Development Control
Ribbles Valley Borough Council

Re: Planning Application 21/0241

Address: 20 Hippings Way Clitheroe Lancashire BB7 2PQ

Description: Proposed two storey extension to the side of the house and first floor extension over the existing garage.

1 0 PROPOSED GROUND FLOOR
1 : 100

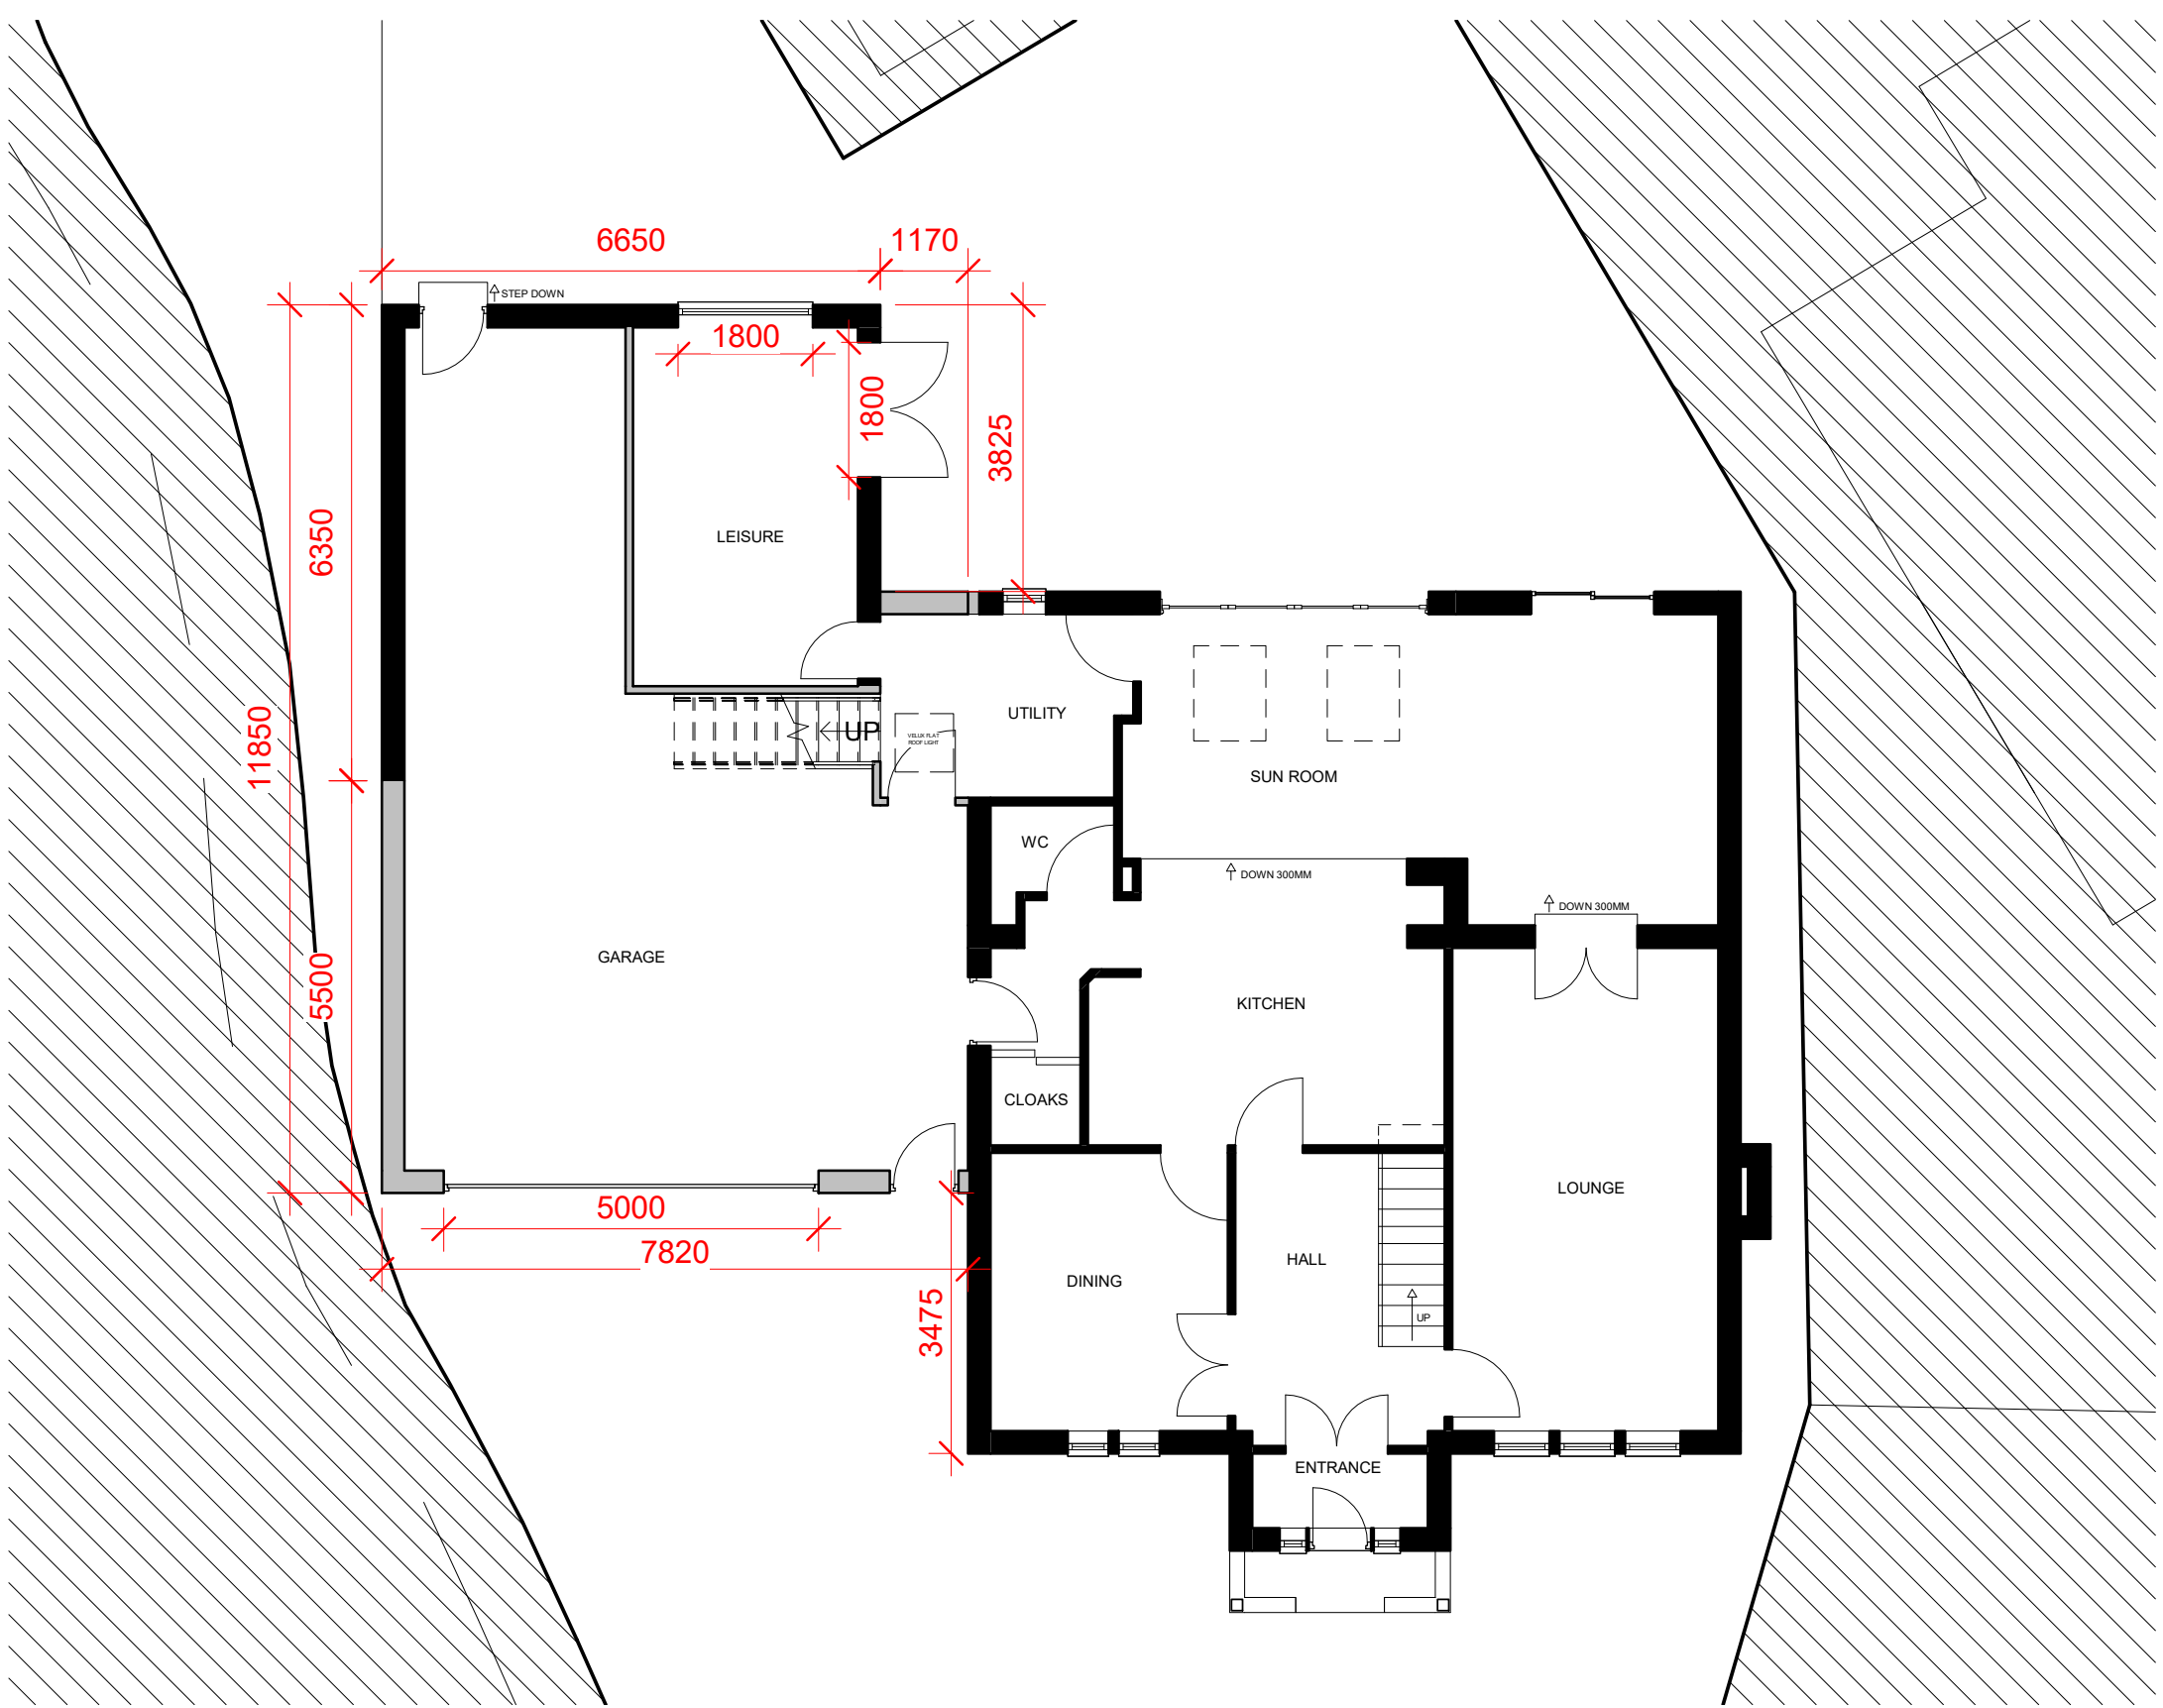
There is no indication as to how the parking allocation is to be achieved. As detailed in Lancashire's Parking Standards a 5 bedroomed dwelling should have 3 off-street car parking spaces. These should measure 2.4m x 4.8m, a space in a garage should measure 3m x 6m, and a driveway space should be a minimum of 5.5m to allow for a garage door to open. Where the driveway is also the shared pedestrian access and additional 0.8m should also be provided. In order to create an accessible parking space, at least two of the spaces should be individually accessible.

In order to progress the application, we would look for further plans indicating how the parking standards can be achieved. It is noted that there is no footway at this point and the service strip should not be included in the parking provision. The plans should show the edge of the carriageway and services strip.
